SUBJECT: Engineering Review Comment
Mountain View Electric Association Inc. (MVEA)

Project Name: The Shops Filing 2 at Meridian Ranch

Project Number: VR2314

Description: Proposed replat into 2 lots for a commercial development of a fueling station located 11810 Stapleton Dr. and Meridian Rd. in Township 12S, Range 64W, Section 30.

# FINAL PLAT

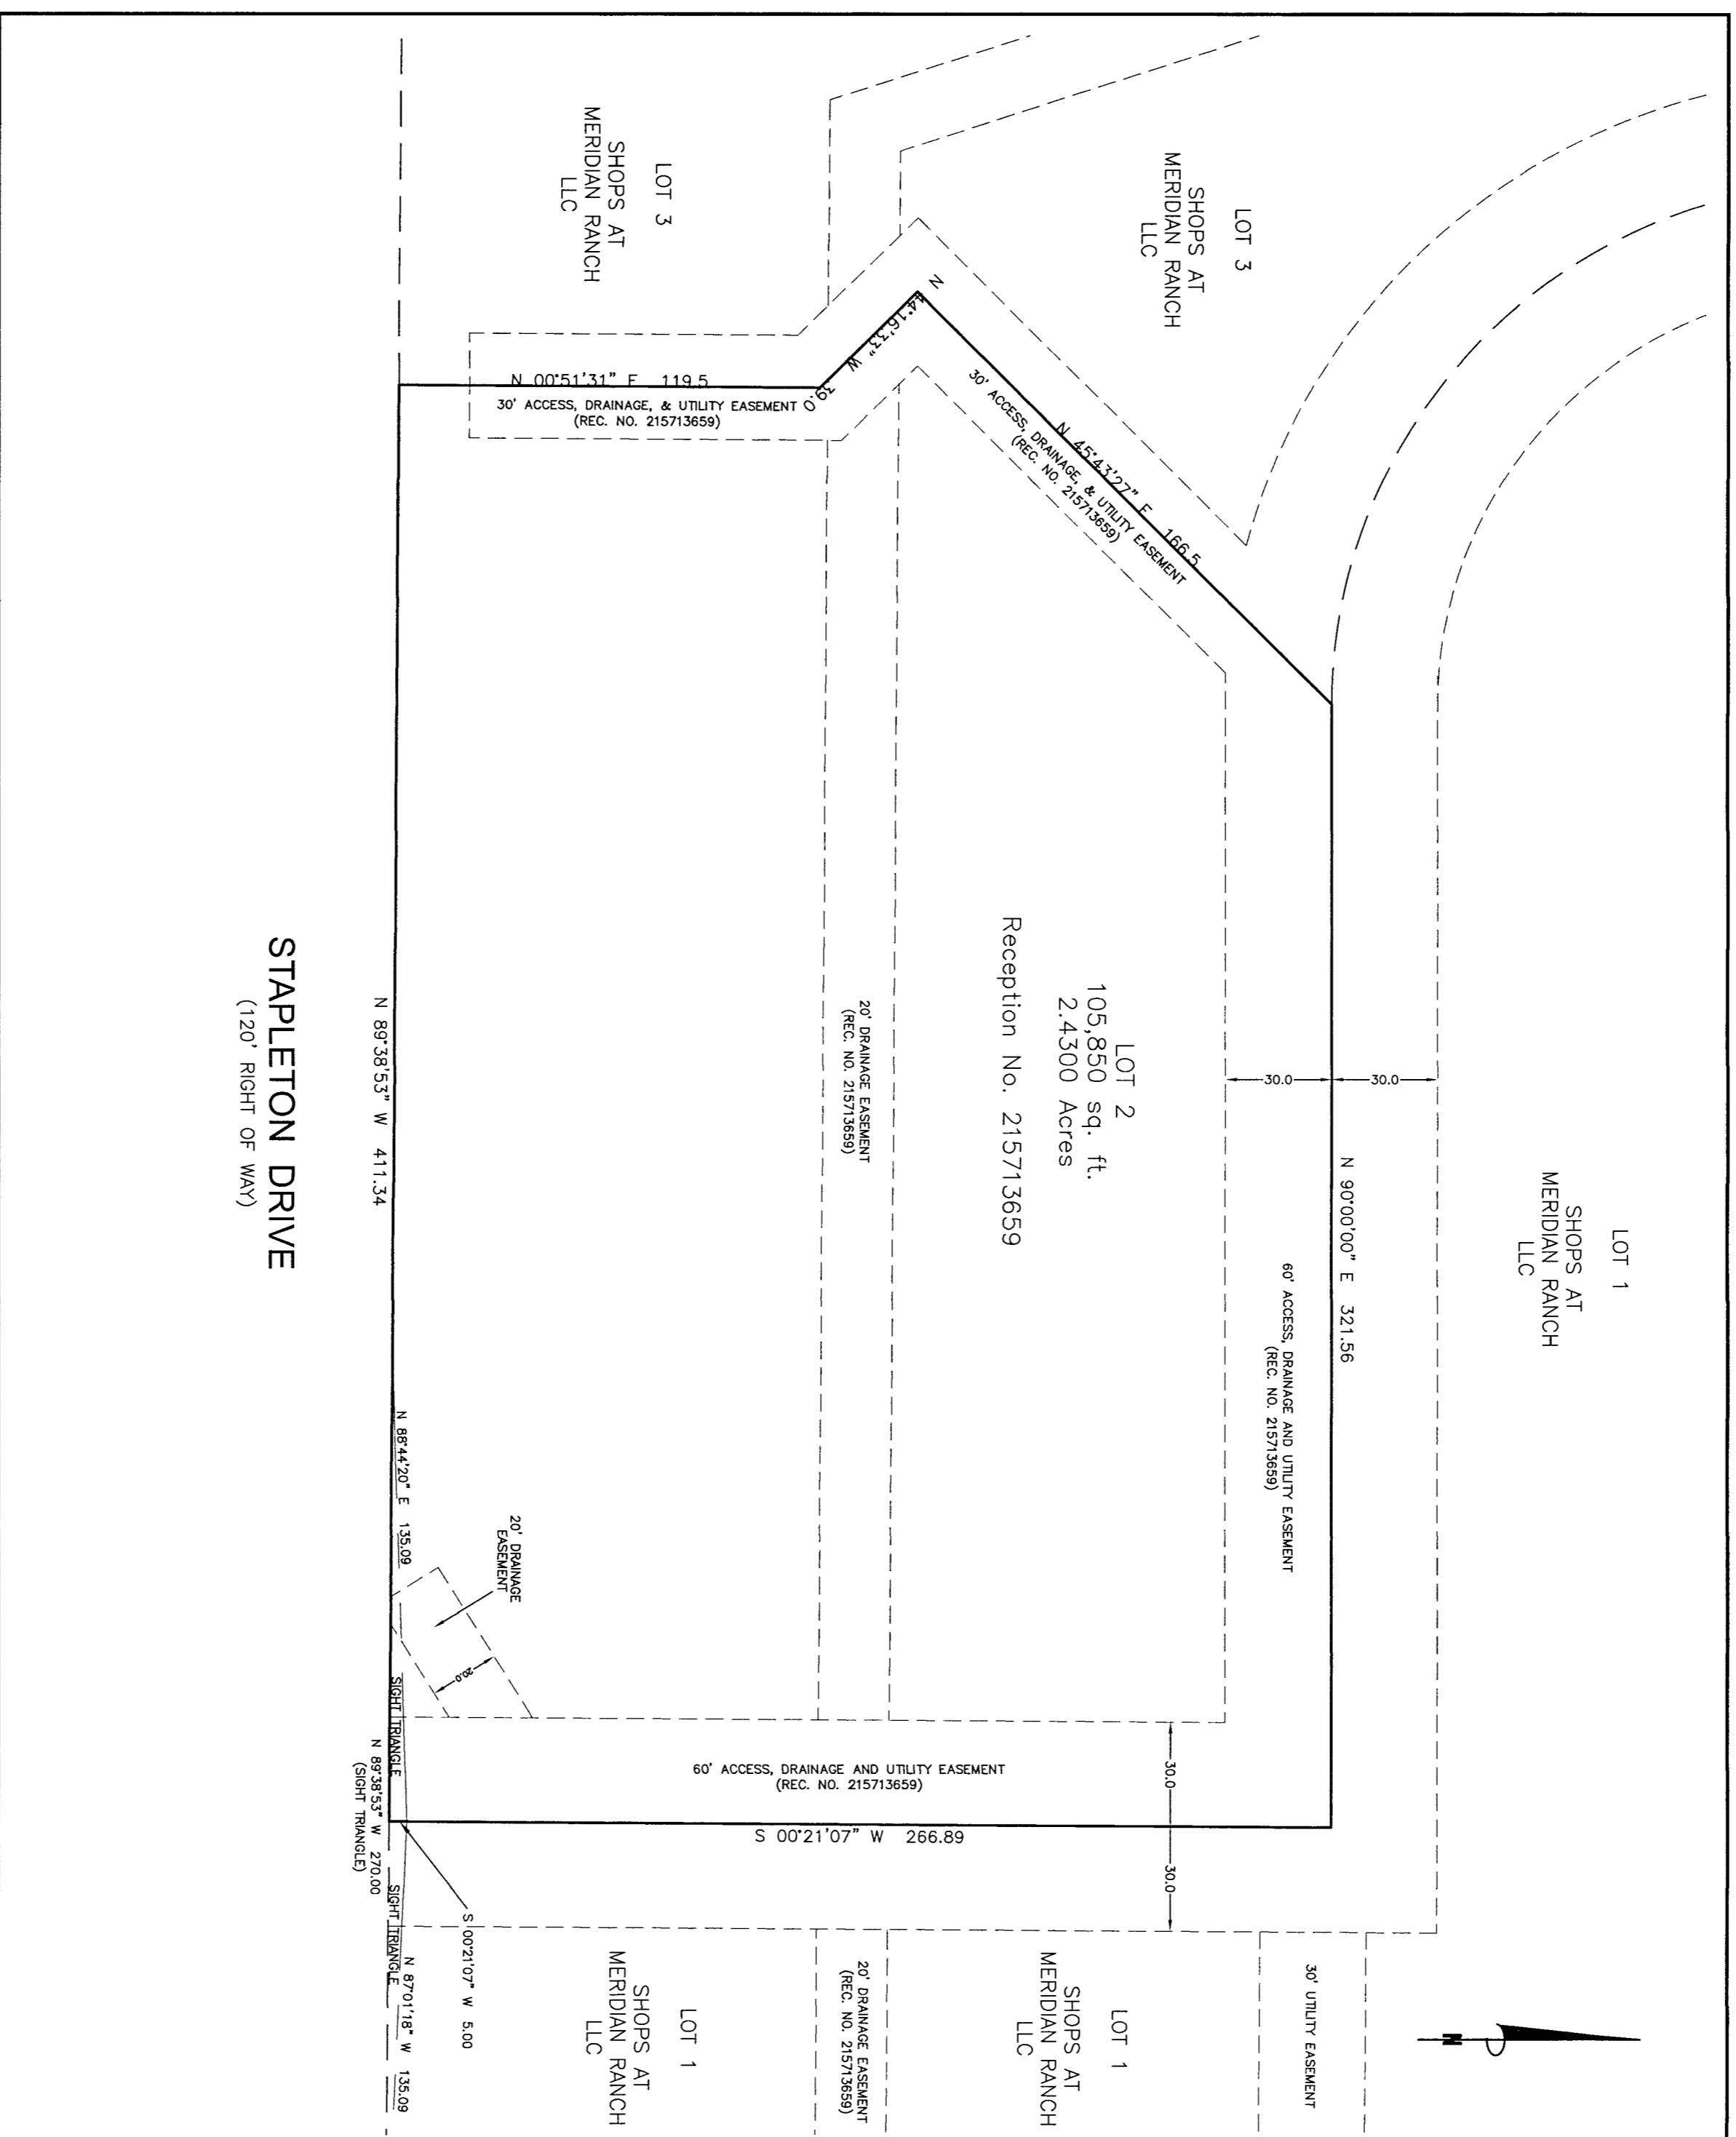
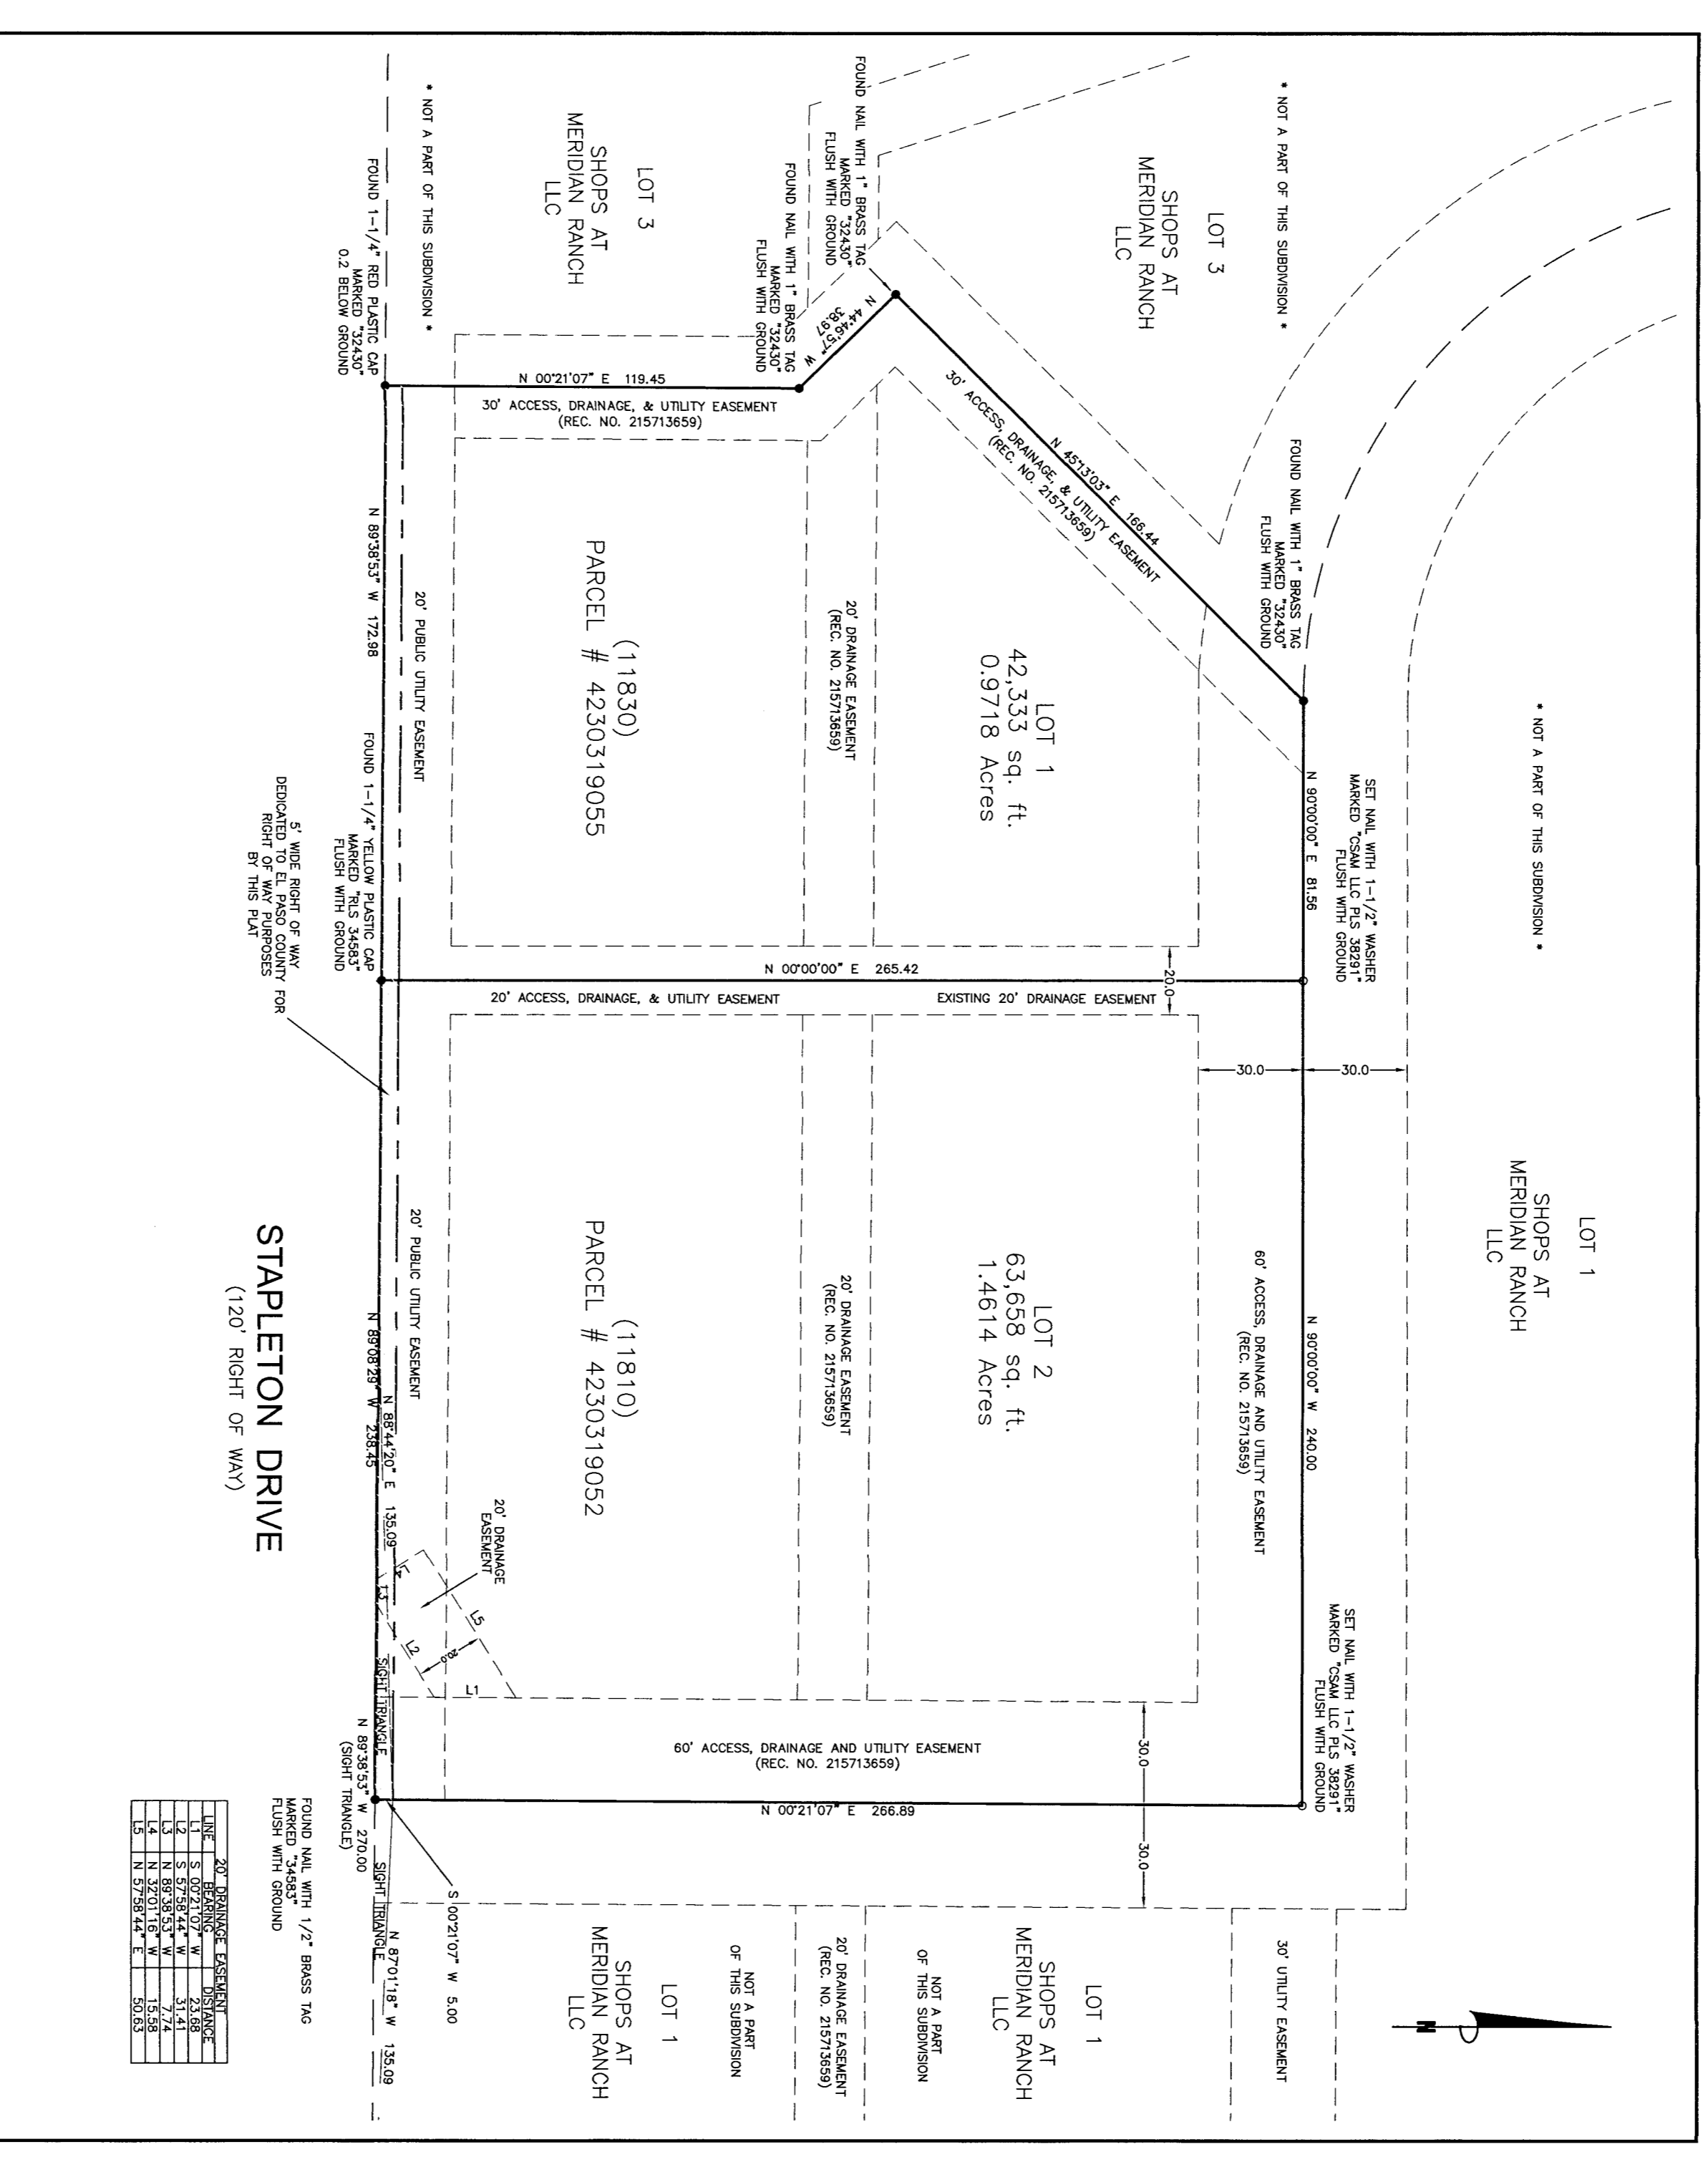
MVEA requests twenty (20) foot front, side, and rear utility easements on commercial lots and will work with the developer on the design of the electric service and to acquire any additional easements. MVEA also requests the platting of MVEA's existing facilities with easements on the plat.
